From: Brereton, Steven [Steven.Brereton@lancashire.gov.uk]
Sent: 28 June 2013 12:45
To: Jane Tucker
Cc: Graeme Thorpe; Lorimer, Elliott
Subject: RE: Consultation on planning application 3/2013/0357 land north of Huntroyde Home Farm, Huntroyde West, Whins Lane, Simonstone.

Subject: Consultation on planning application 3/2013/0357 land north of Huntroyde Home Farm, Huntroyde West, Whins Lane, Simonstone.

Please can we have your comments on the above planning application? It is for the proposed erection of a 60.7m single wind turbine on land to the north of Huntroyde Home Farm, Huntroyde West, Whins Lane, Simonstone. I have attached the formal consultation letter and here is a link to view the application documents on our website

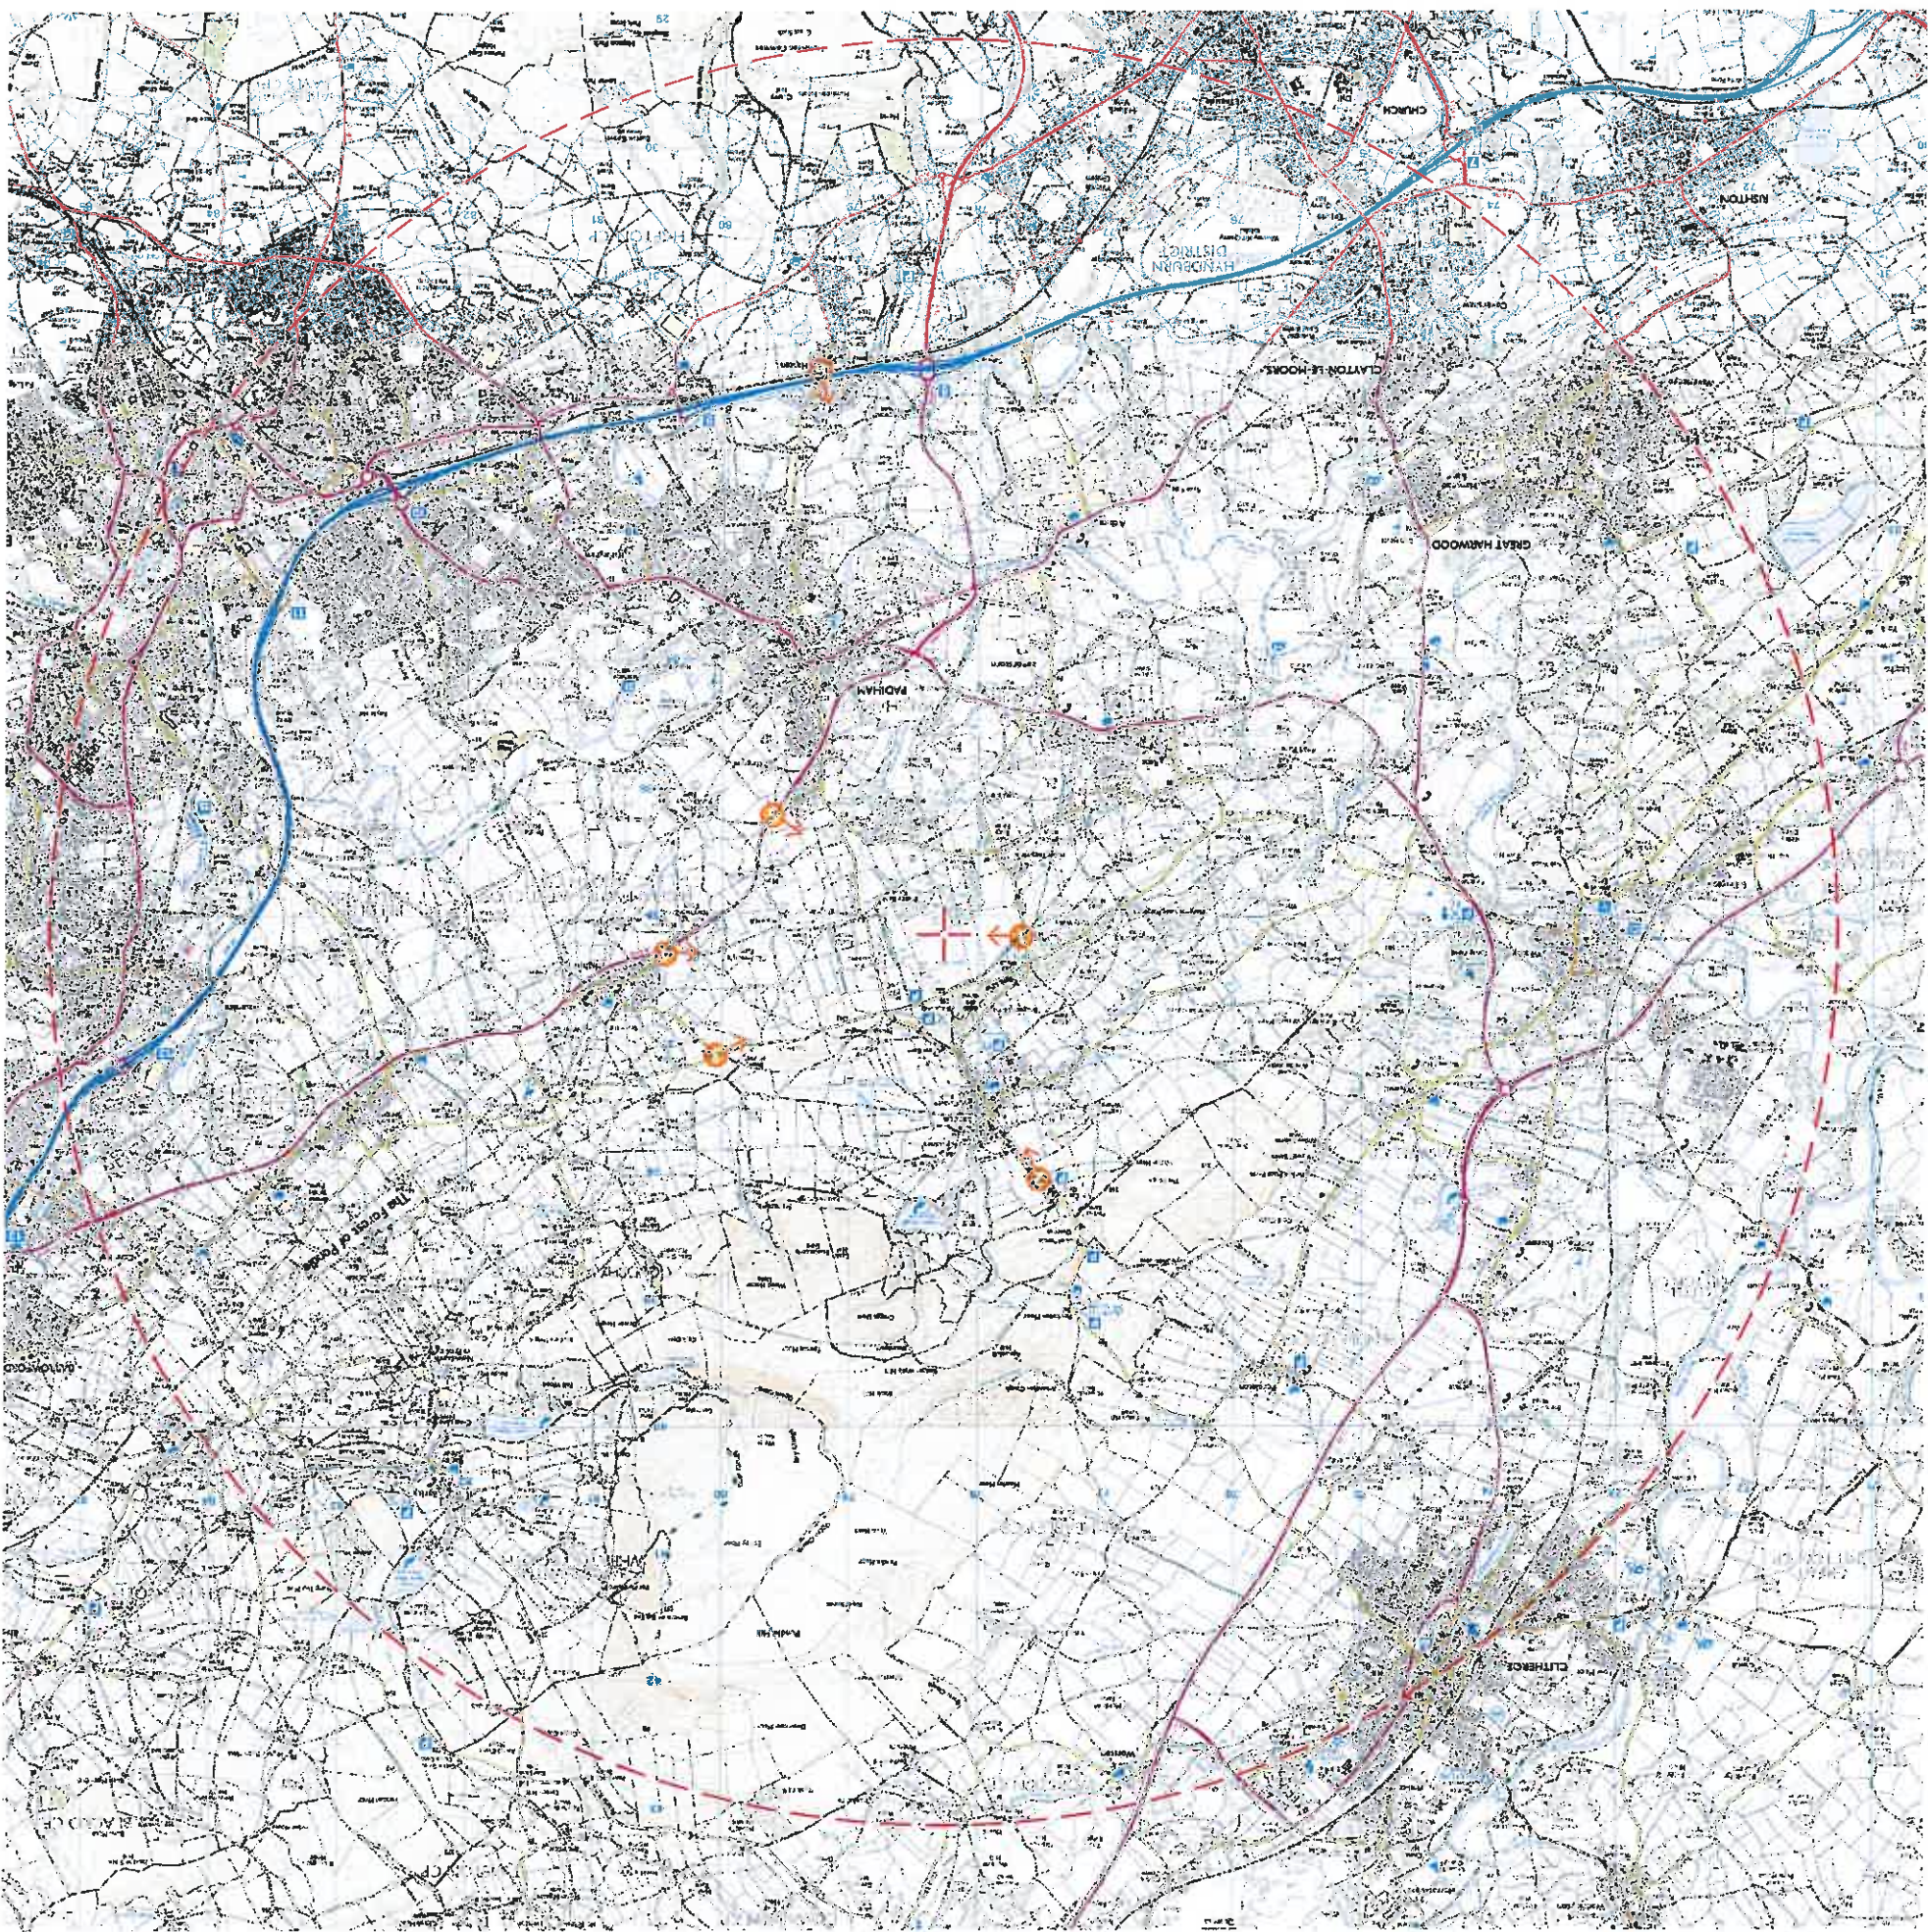
SNH guidance *Natural Heritage assessment of small scale wind energy projects which do not require formal Environmental Impact*

Assessment (EIA), March 2008 recommends a "ZTV map out to 30km" for schemes containing up to 3 turbines over 50m in height. By contrast, on the Huntroyde Home application a study area of just 7km radius has been used. Such a small radius means that the elevated areas to the north and north west of the site which are within the AONB e.g. Longridge Fell and Waddington Fell are not covered by the assessment.

The applicant in his response (17th June 2013 letter, ref. DS/146BN) to comments made by Natural England on the small radius of the study area attempts to justify a 7km study area radius by referring to other parts of the country where it was considered acceptable. In doing this the applicant fails to recognise that drawing comparisons between applications in completely different parts of the country is of very little use because all these areas have different topography, landscape character, levels of visibility, landscape tranquillity, etc, etc. The applicant in his response also draws attention to SNH guidance on the matter but omits to make reference to this key point from the guidance in relation to the radius of a study area: *"It is advised that determination of the extent of the ZTV should be discussed and agreed with the determining authority and consultees."*

Taking account of the location of the application site, scale of the proposed wind energy development, location of nationally important landscapes, topography and likely visibility of the turbine, I consider that a study area radius of 15km is appropriate and reasonable (although I have no objection to a 20km radius as highlighted by Natural England).

project title
figure title
figure reference
scale
date
N160: Huntroyde
Viewpoint 1: Trapp Lane, Whittle Hill
N160-GR-LVIA-013
1:25,000 @ A3
February 2013

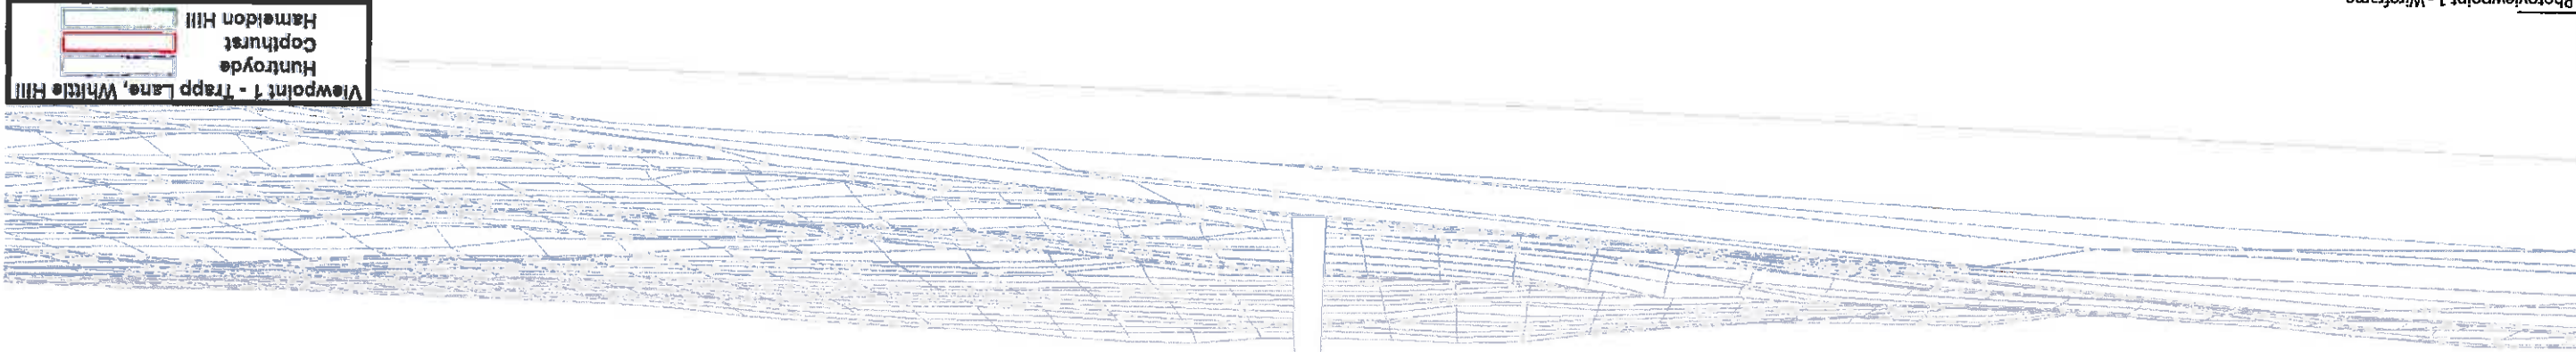
Viewpoint 1 is of little use as only the very tip of a turbine blade would be visible; information easily gleaned from the ZTV maps and topographical data. In viewpoint 2 the wind turbine is partly obscured by trees and in viewpoint 4 the turbine could not be seen.
